Final Report - Corrections Required **Application No. DEPN-26-0063**

Description : Single Family Detached residential development located north of New Life Drive in the Flying Horse Master Plan

Document Filename : DP Creekridge at Flying Horse Filing No 1.pdf

DESIGNED BY	JRH	SCALE	DATE	4/29/26
DRAWN BY	JRH	(H) 1"= 40'	SHEET	11 OF 24
CHECKED BY		(V) 1"= N/A	JOB NO.	1171.78

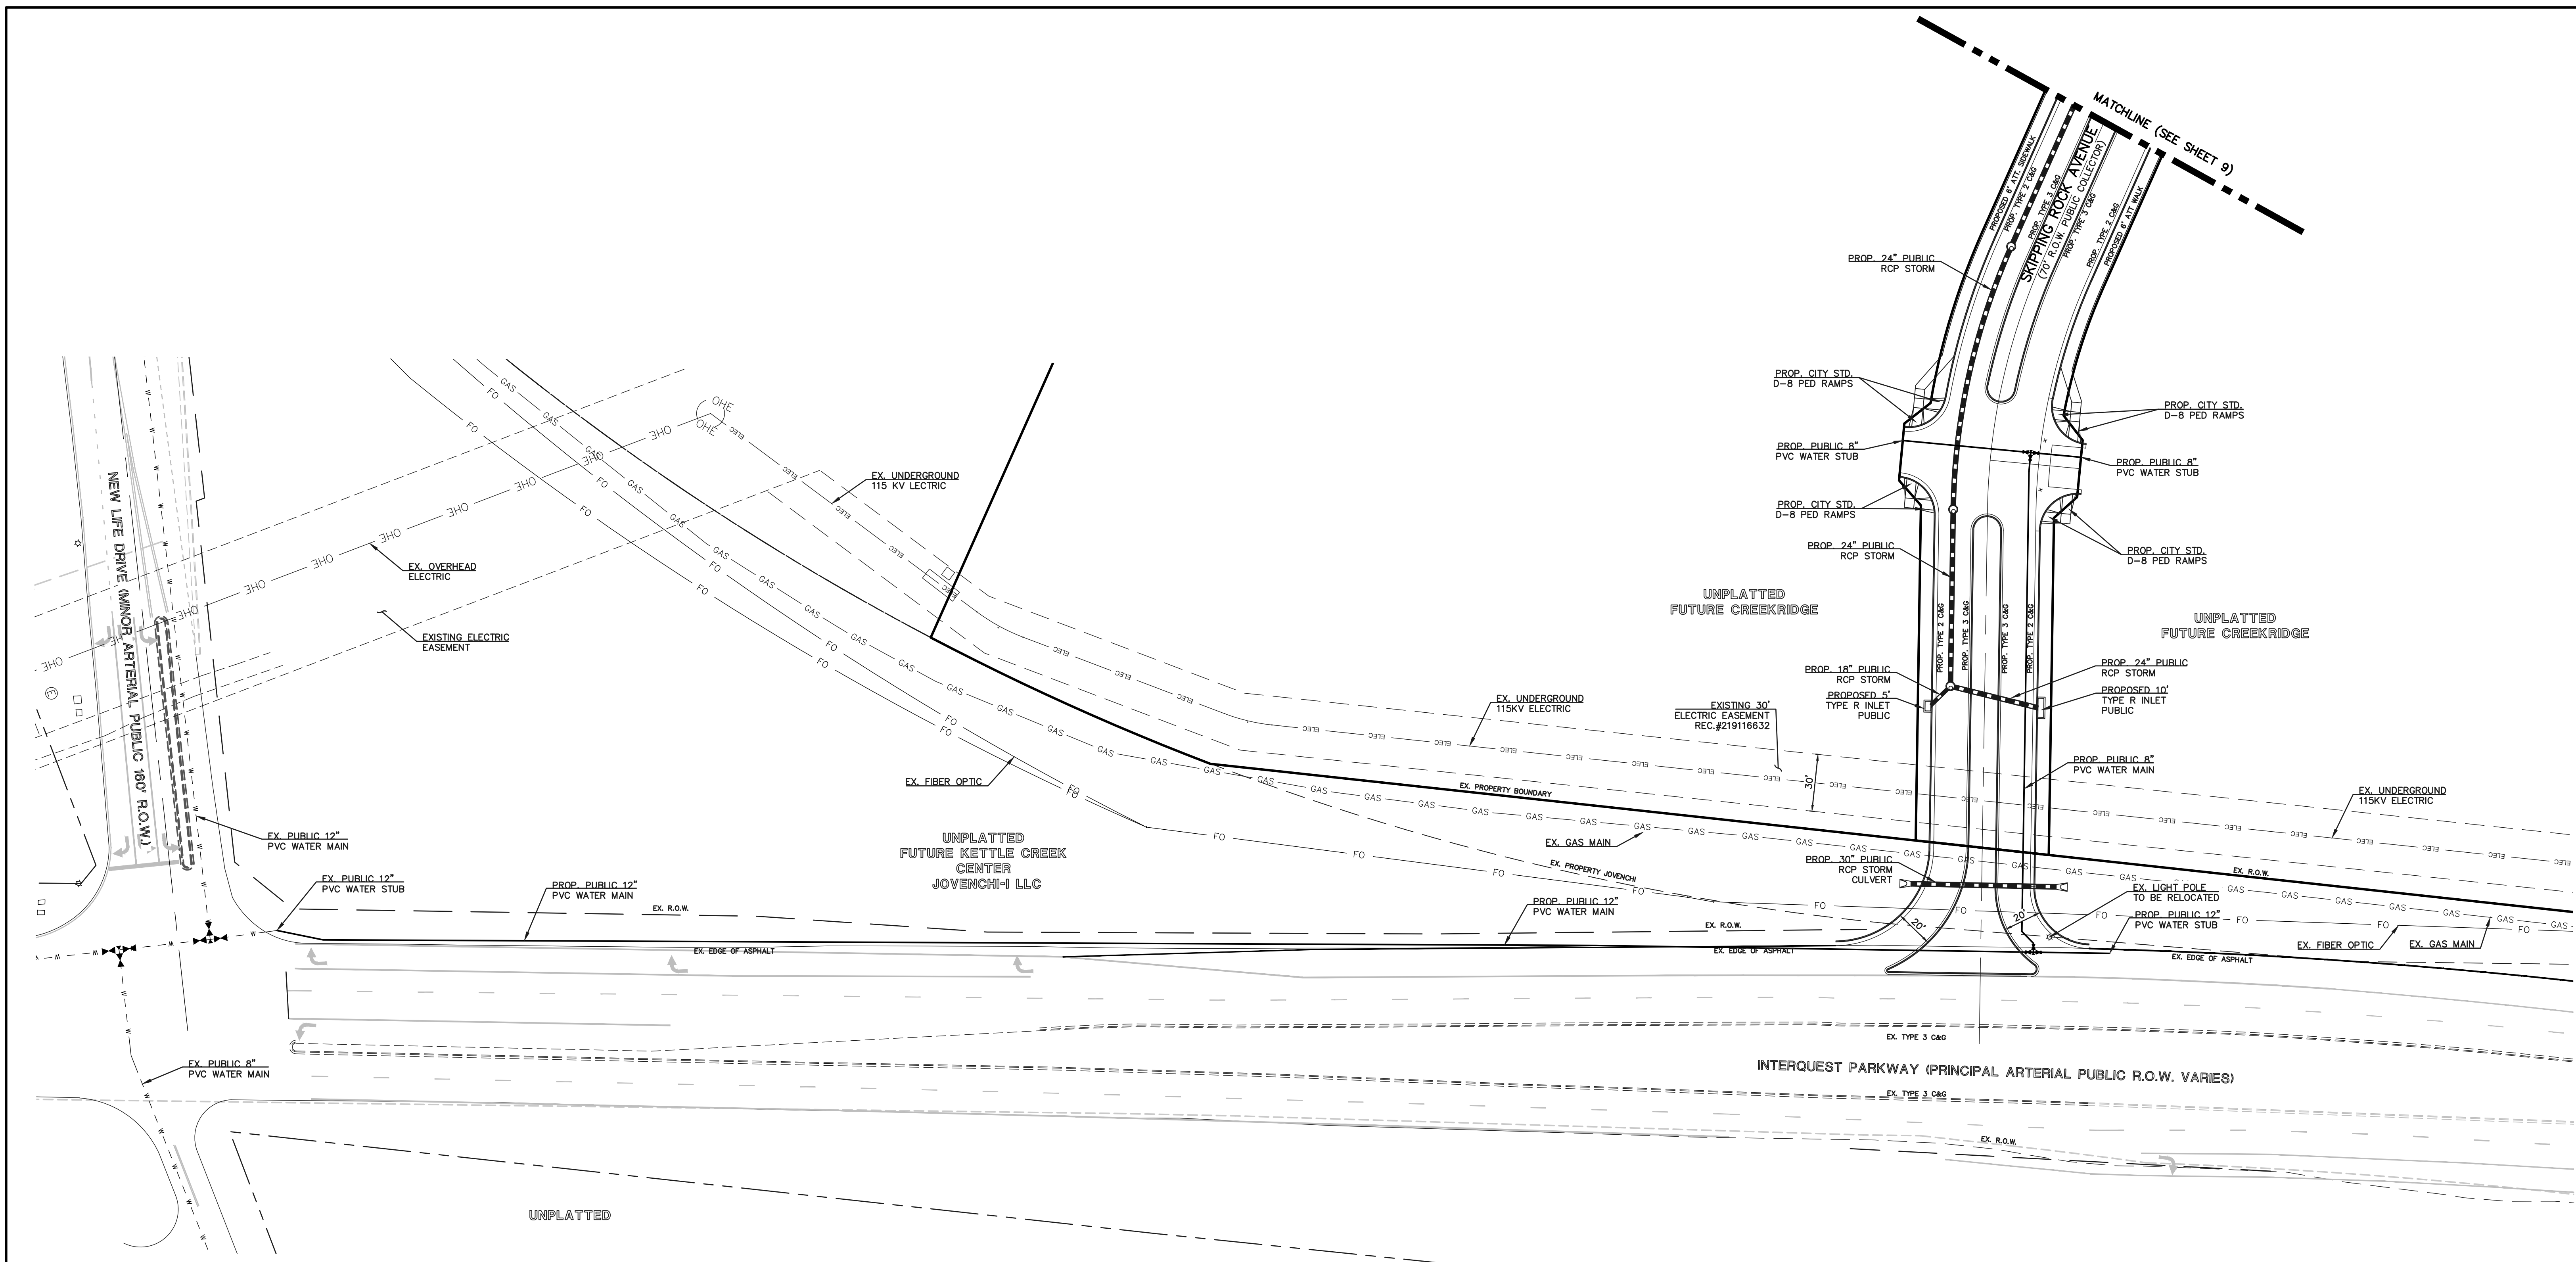
45	11	Matthew Alcuran : Col Springs Utilities	Need to have 10ft of separation between waste water and water main. Add dimension to ensure horizontal separation is met.
46	11	Matthew Alcuran : Col Springs Utilities	Call out new connection to existing wastewater main.
47	11	Matthew Alcuran : Col Springs Utilities	Call out new connection to existing water main.
57	1	Steve Smith : Fire	Please provide a second non-emergency, access point per code below. D107.1 One- or two-family dwelling residential developments. Developments of one- or two-family dwellings where the number of dwelling units exceeds 40 shall be provided with two (2) separate and approved fire apparatus access roads unless otherwise required by the fire code official.
42	1	Gregory Stachon : Planning	•"All street trees and streetscape improvements located in the ROW will be maintained by {choose one – Home Owner/HOA/Metro District or by the abutting property owner}."

JOB NUMBER	2787-0326
DATE	5/5/2026
DRAWN BY	MB
DRAWING DESCRIPTION	FINAL LANDSCAPE PLAN
SHEET #	L-3 18 of 24

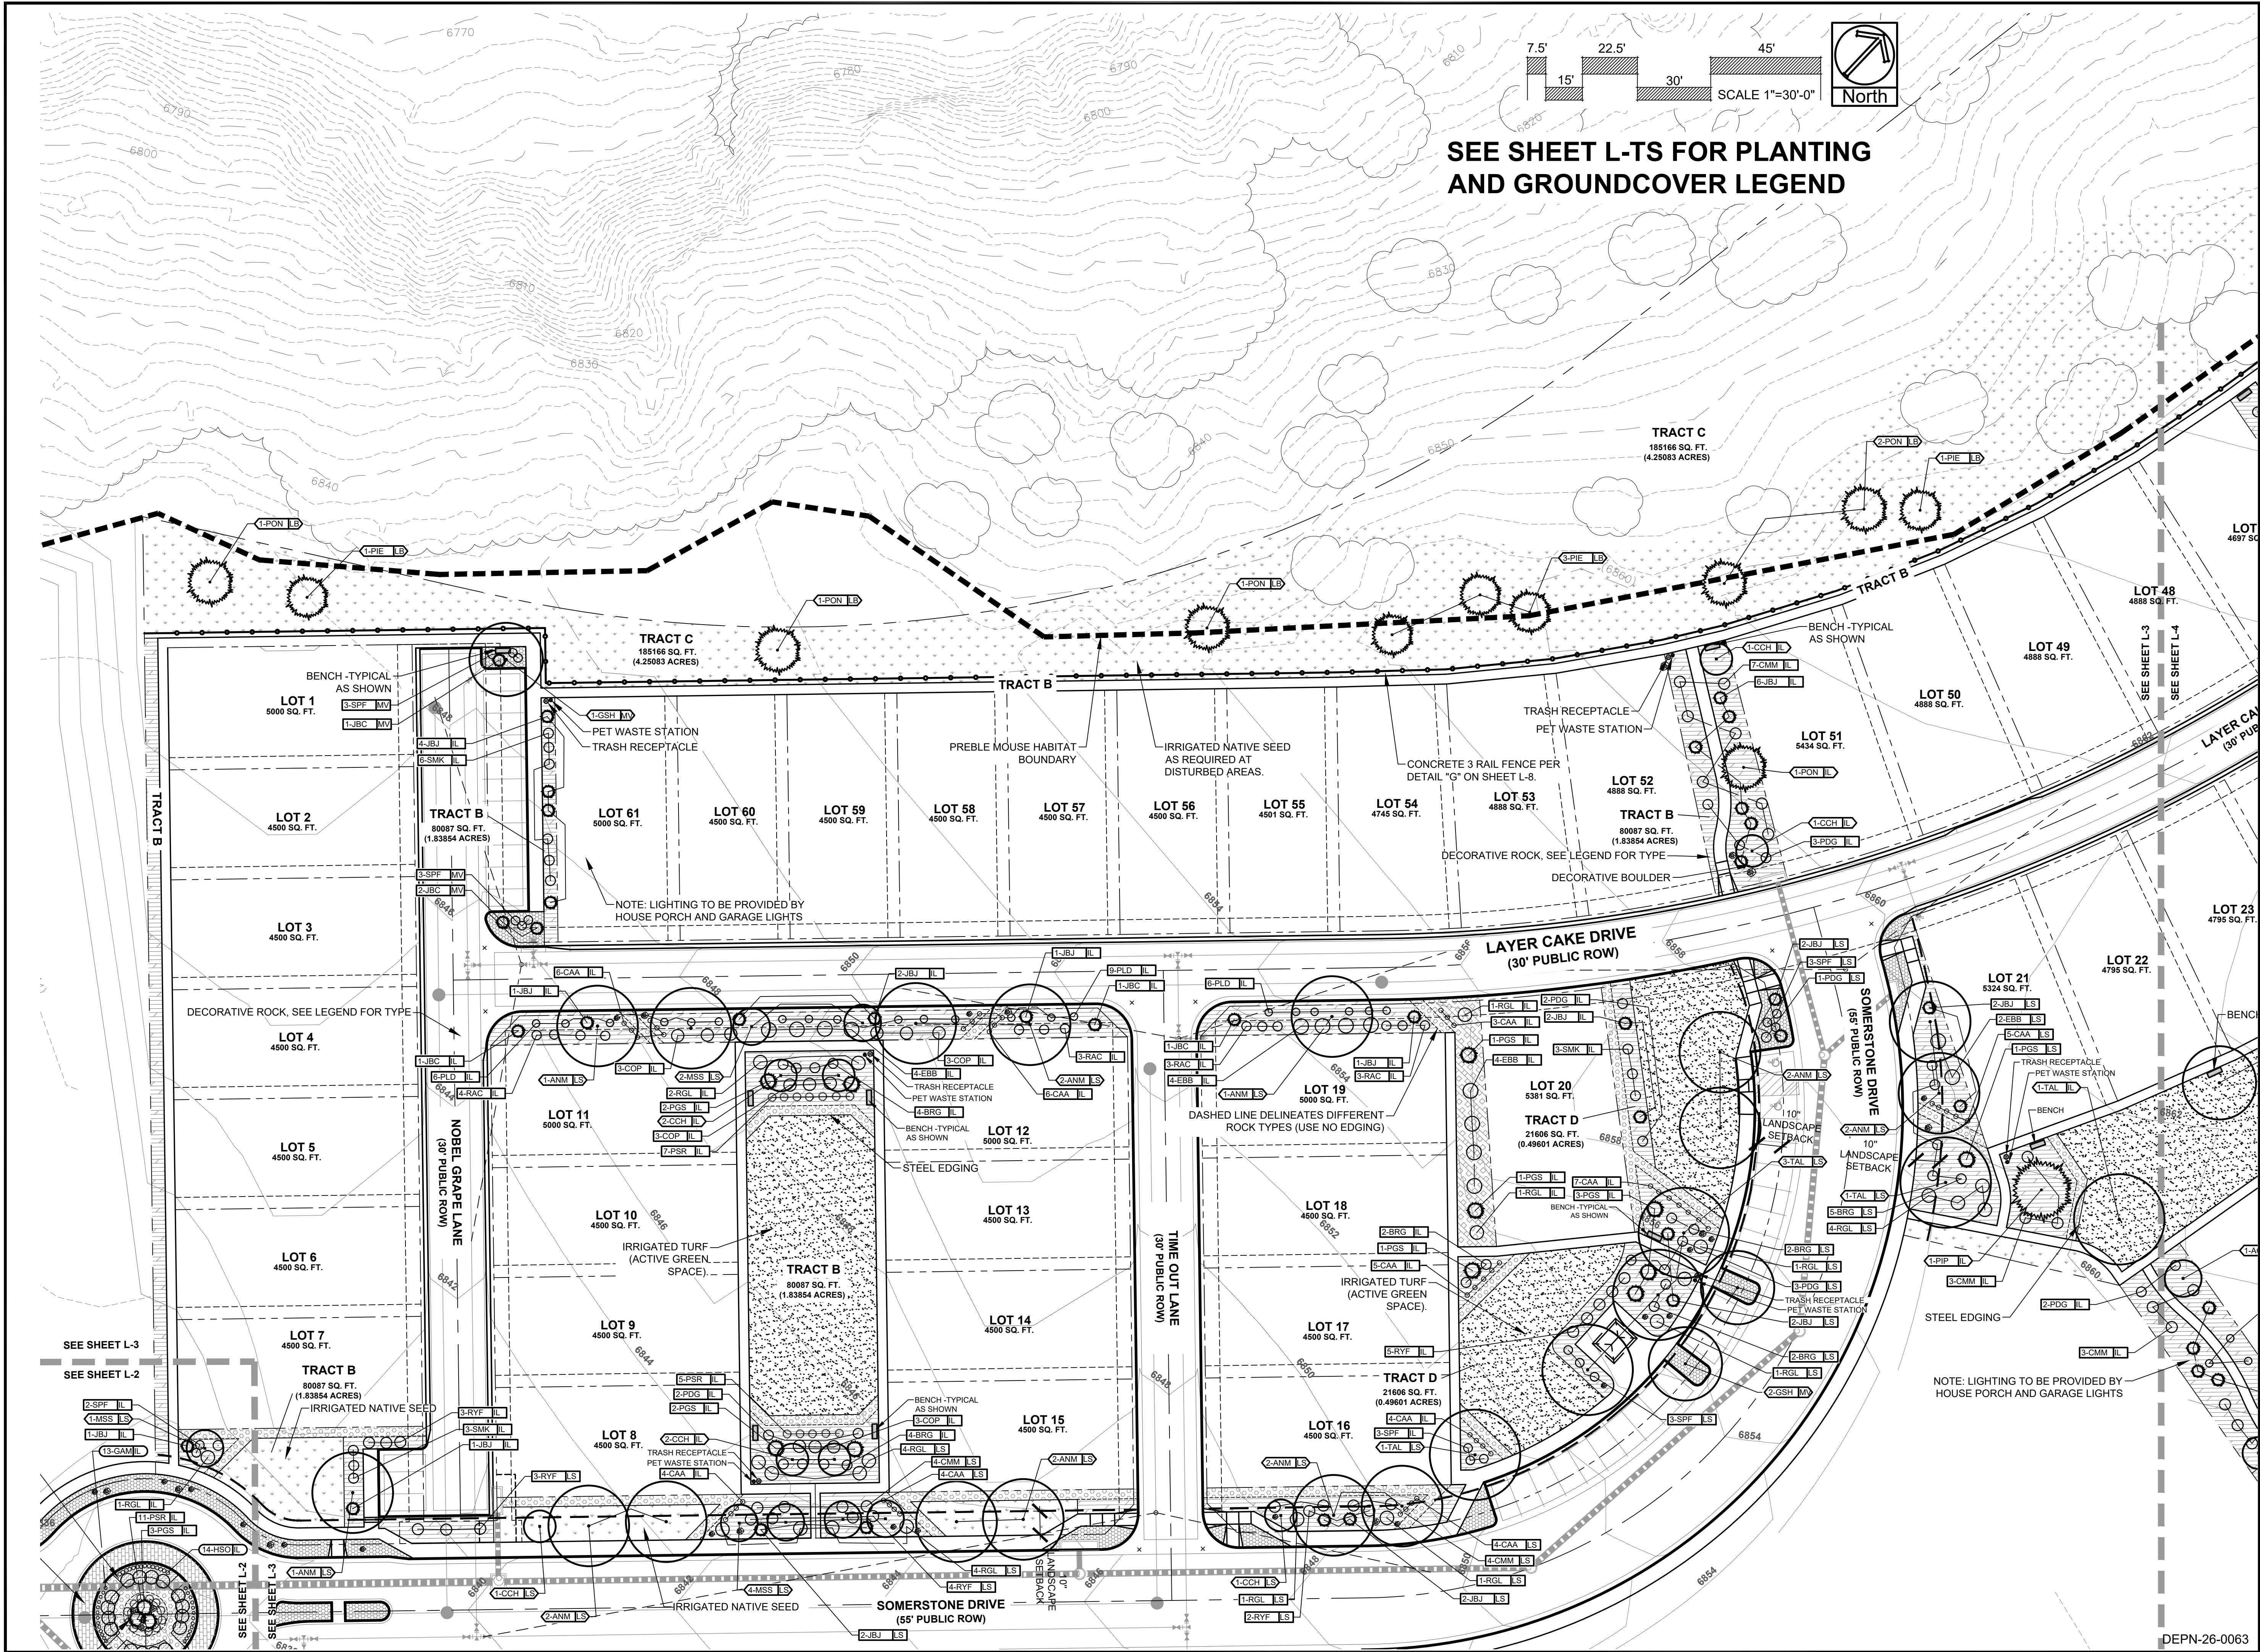
36	14	Gregory Stachon : Planning	confirm that any high water turf is "active green space" or "functional" areas only. No turf as infill.
37	17	Gregory Stachon : Planning	how is this turf area functional? Looks more like infill.
38	17	Gregory Stachon : Planning	label proposed turf areas as "Active Green Space"
39	18	Gregory Stachon : Planning	Native seed should not be used in small visible areas (COS Landscape Manual Appendix B)
40	18	Gregory Stachon : Planning	label turf as "Active Green Space"
87	18	Allison Stocker : Planning	Has there been any consideration to add additional trees along this side of the development to help provide additional sound buffering?
41	21	Gregory Stachon : Planning	Information Only: Provide soil amendment chart and notes at Final Landscape Plan. Amendments to be based on horticultural soil testing.
64	22	Allison Stocker : Planning	Please include the 3' habitat fence typical
